Response table to WSCC (LLFA) issues raised (extract) to planning application AL/89/24/OUT

SURFACE WATER DRAINAGE STRATEGY AREAS 2&3

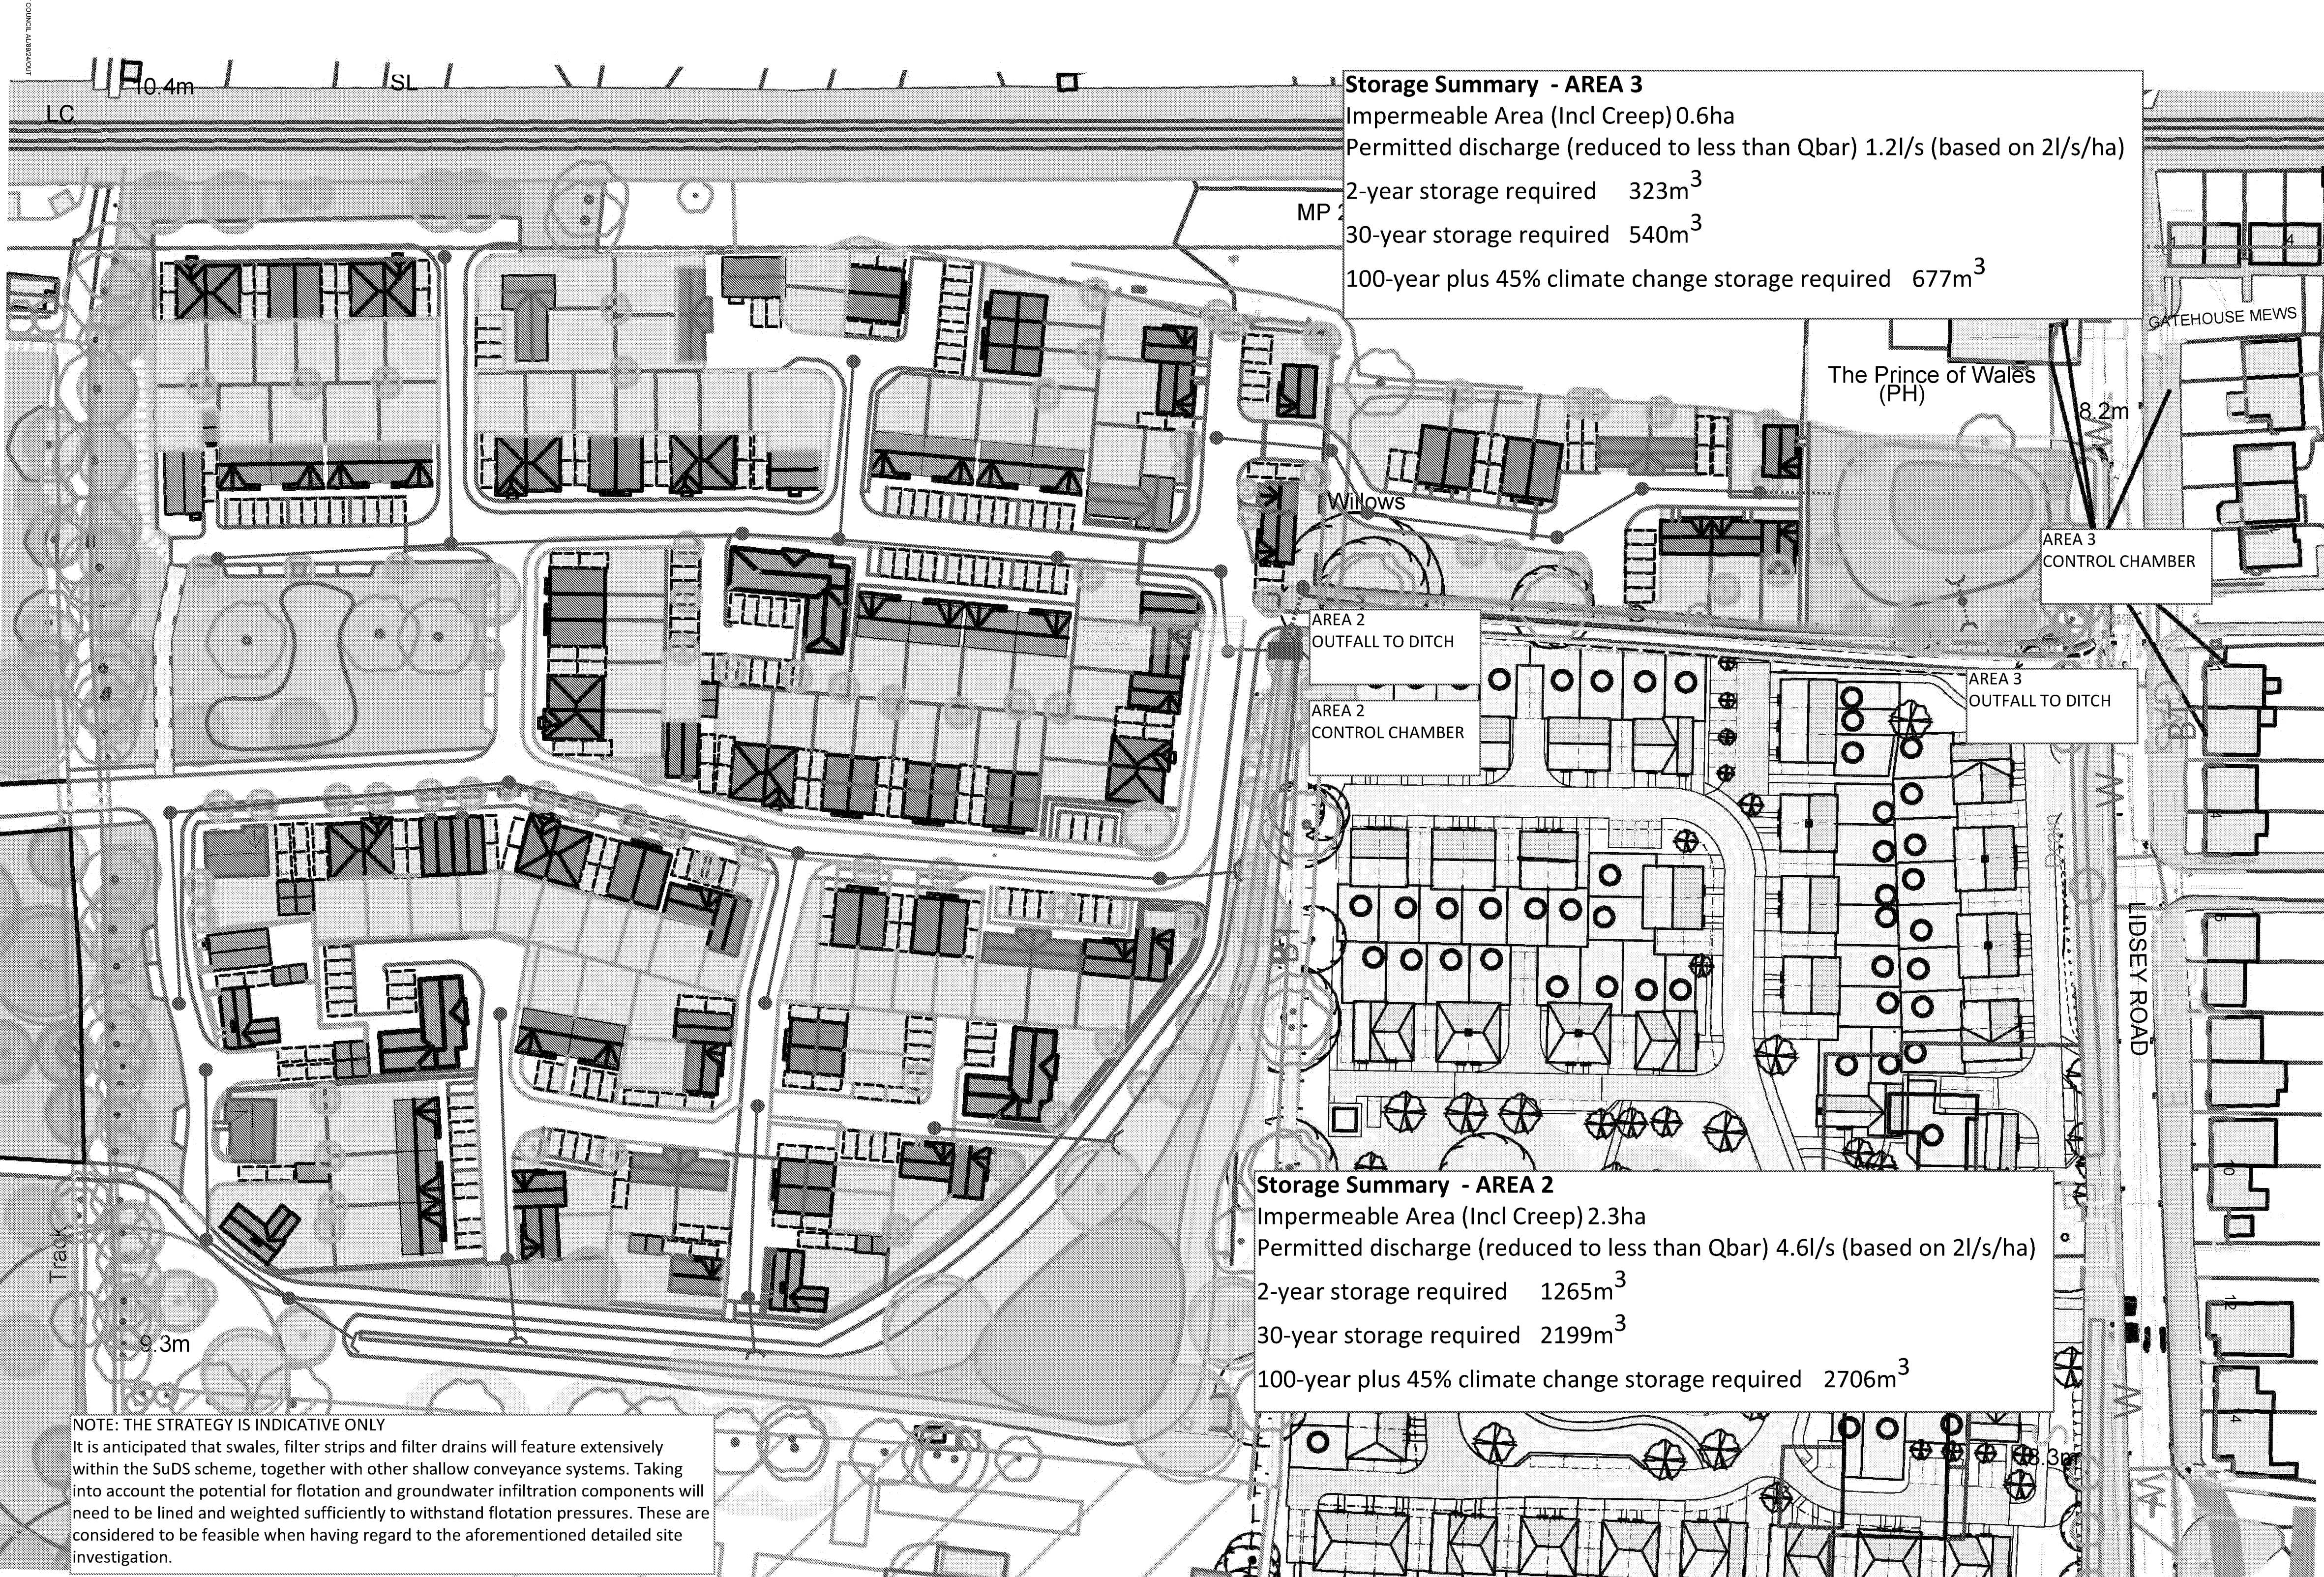
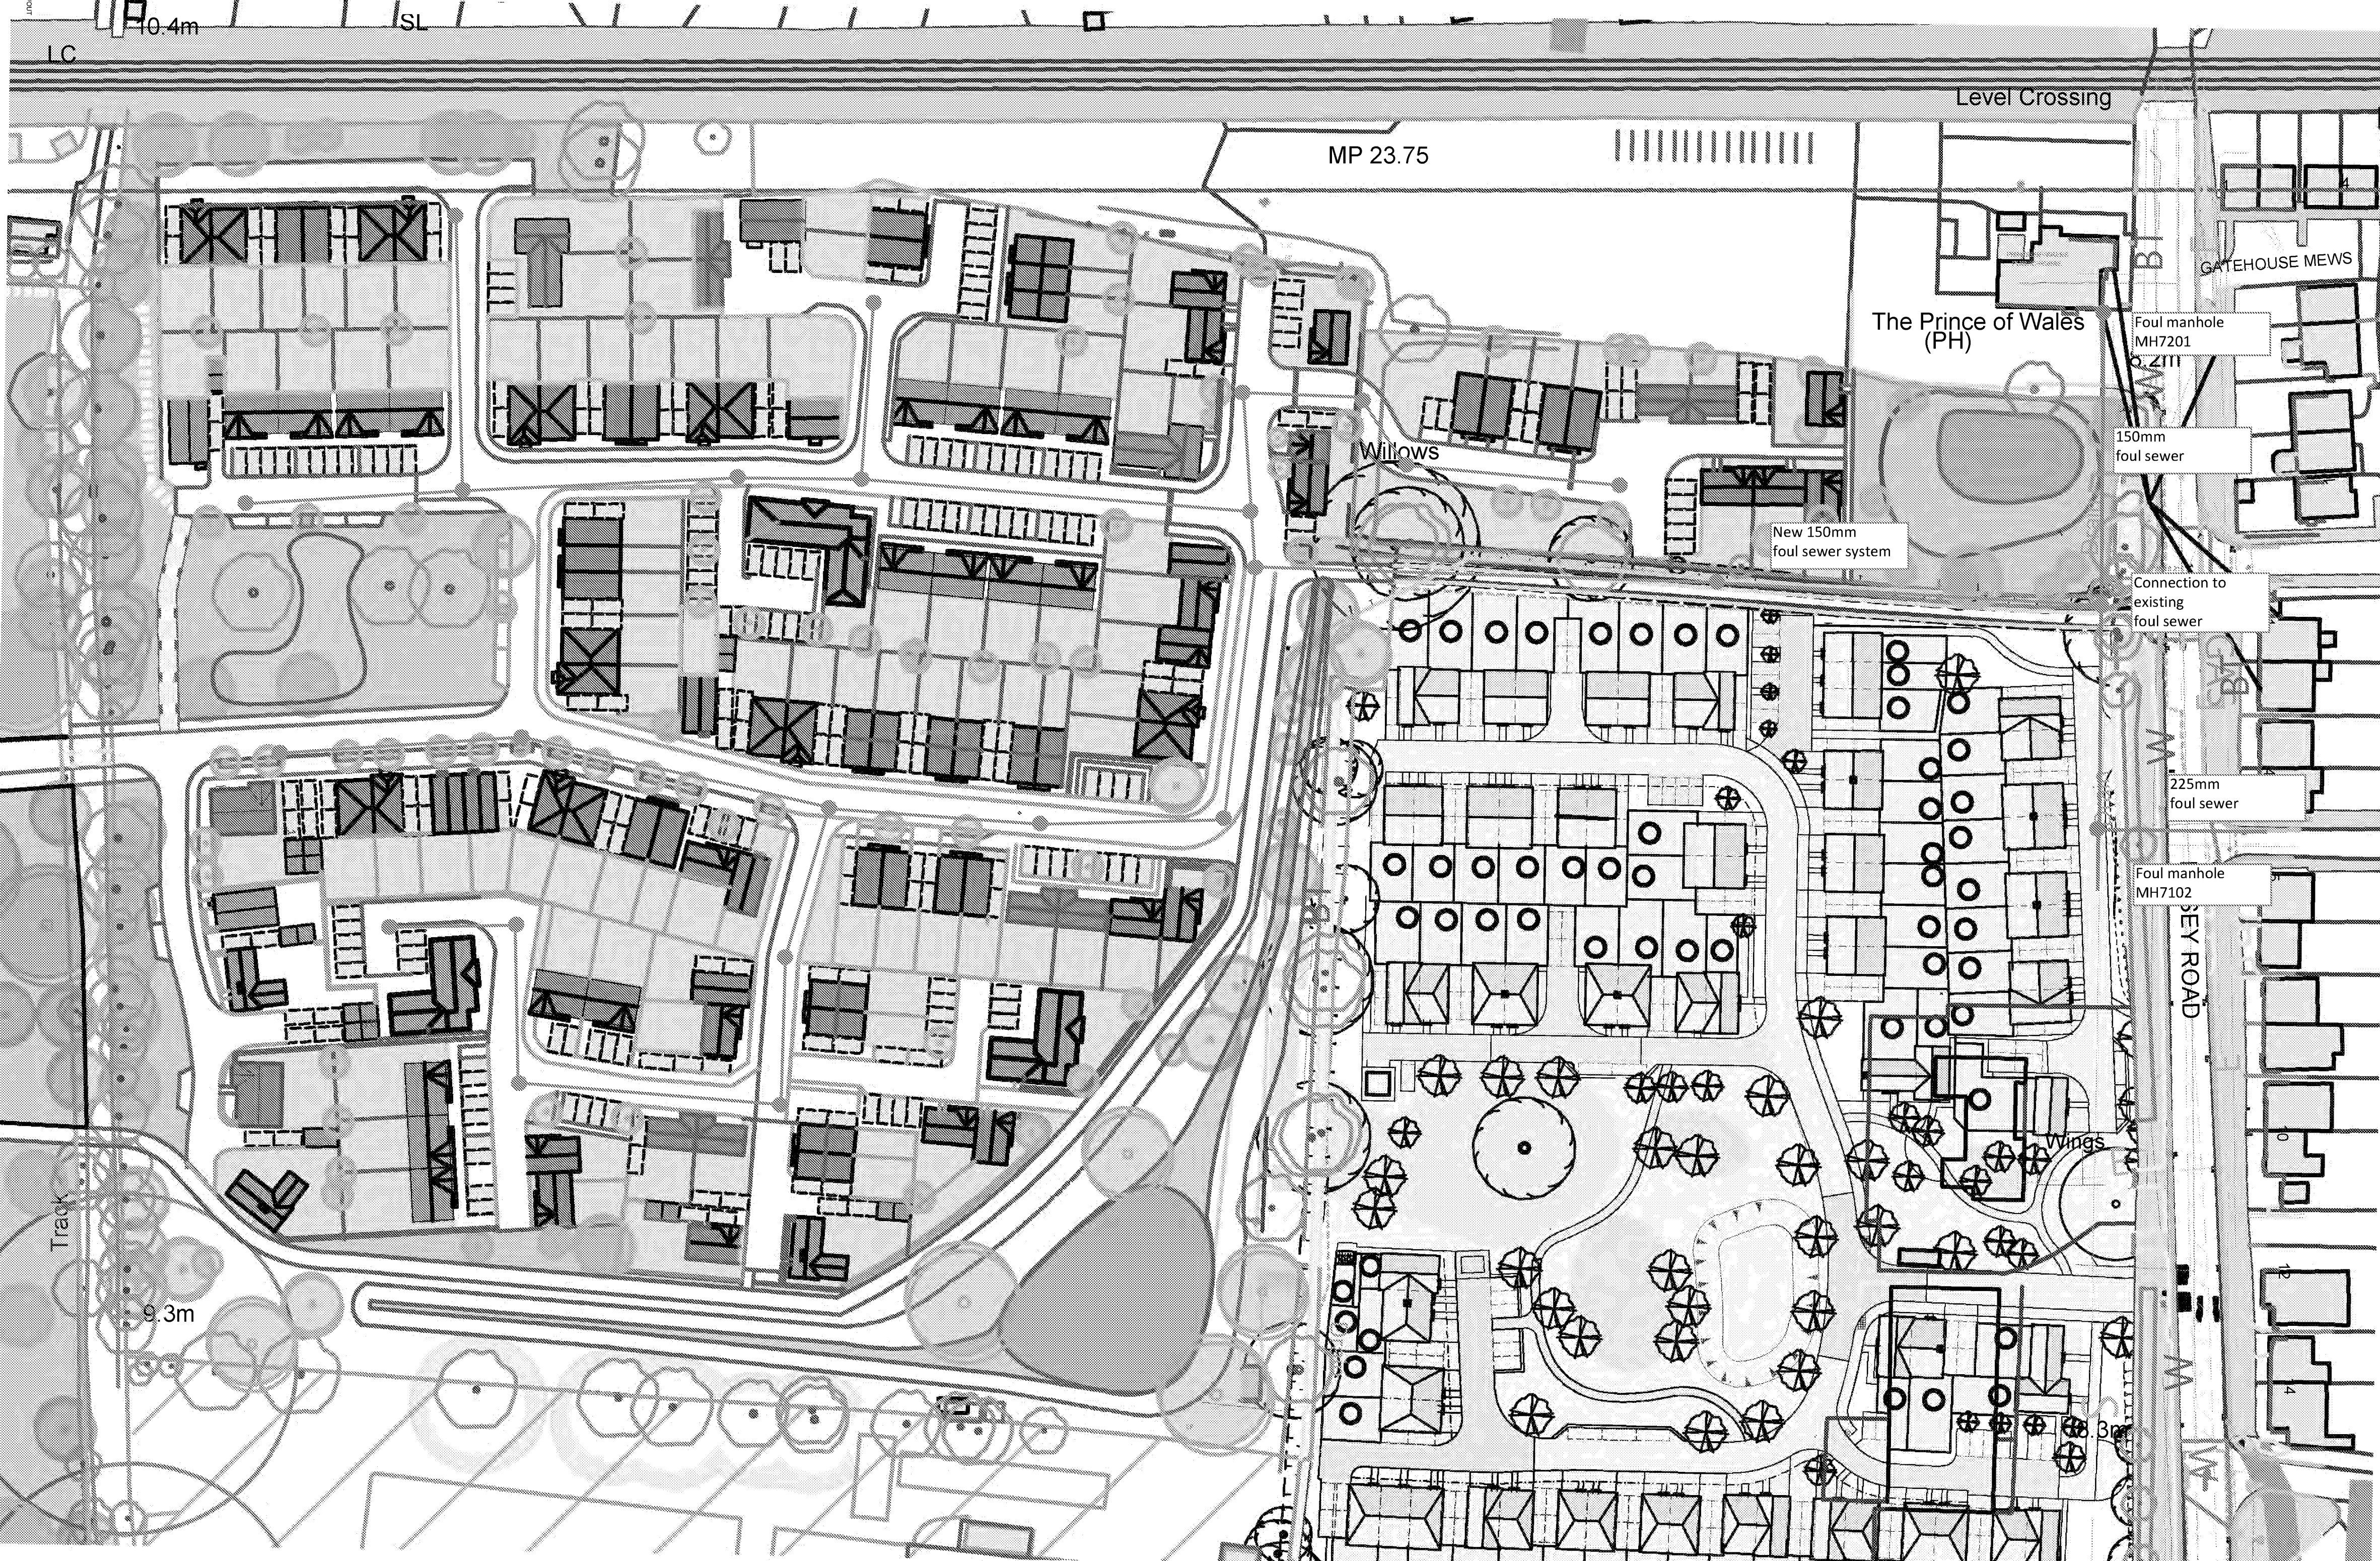
Proposed discharge rates and volumes are greater than greenfield with no justification.	Objection: The proposed discharge rates are based on the impermeable area plus an allowance for urban creep, therefore discharge rates are higher than greenfield.	The proposed discharge rates are based on greenfield runoff (Qbar). The contributing area is from impermeable areas only, this is explained at Section 5.5 (This was ADC Policy). The assessed discharge rates are lower than the greenfield runoff rate for each sub-catchment.
		Proposed discharge rates include future allowances for climate change	Objection: The proposed discharge rates are based on the impermeable	See answer above.

and/or urban creep. These must be removed and all calculations resubmitted.	area plus an allowance for urban creep, therefore discharge rates are higher than greenfield.	
		Proposed discharge rates would increase flood risk elsewhere and need to be re-assessed.	Objection: The proposed discharge rates are based on the impermeable area plus an allowance for urban creep, therefore discharge rates are higher than greenfield.	See answer above.
		Include appropriate climate change allowance for the lifetime of the development (including 3.33% AEP design) for storage volumes.	Objection: Please provide storage volumes for the 3.33% AEP event plus climate change. (45%)	The 1 in 30 yr event is already accommodated by storage designed to attenuate the more significant volumes in a 1:100 year event, plus CC already demonstrated for the site. See sections 5.14 to 5.16 showing the calculated 3.33% AEP event plus climate change. (45%) volumes for each subcatchment. The volumes are also shown on the drainage strategy in Appendix 6.

Outline drainage modelling calculations should be resubmitted and demonstrate how 10% urban creep has been included in the volume of SuDS storage required.	Objection: Please provide further details.	For each of the subcatchments the roof and paved areas have been measured. 10% addition for creep was then added. AREA 1 (Road only) Roof area = 0 Paved area= 0.3Ha Combined=0.3Ha No allowance for creep as access road only

AREA 2 Roof area = 0.7387Ha Paved area= 1.3472Ha Combined=2.0859Ha Creep allowance=0.215Ha Total = 2.3009Ha (2.3Ha) AREA 3 Roof area = 0.0736Ha Paved area= 0.122Ha Combined=0.1956Ha Creep allowance=0.02Ha Total = 0.2156Ha (0.22Ha) NOTE The modelled impermeable area for AREA 3 in the FRA of 0.6Ha is in error. The measured area is 0.22 Ha. This is now corrected and the FRA updated accordingly.
How will the drainage and watercourse features be managed and maintained?	NPPF Paragraph 175 PPG Paragraph 055, 057 and 058 SDNSTS S10, S11, S12, S13 and S14	Provide an easement of a minimum of 3m from the top bank of any watercourse. This should be on both banks, but justification should be provided if access is proposed from only one side of the bank or less than 3m (e.g. 2.5 time the width of any plant likely to be used (from the top of bank with maintenance plant parallel to the watercourse)).	Objection: please show on drawings.	Please note; a) This application is submitted in outline for up to 130 dwellings – layout and landscaping are reserved matters at this stage and are not being considered in detail – therefore showing ‘on drawing’ is not suitable as those are likely to change.
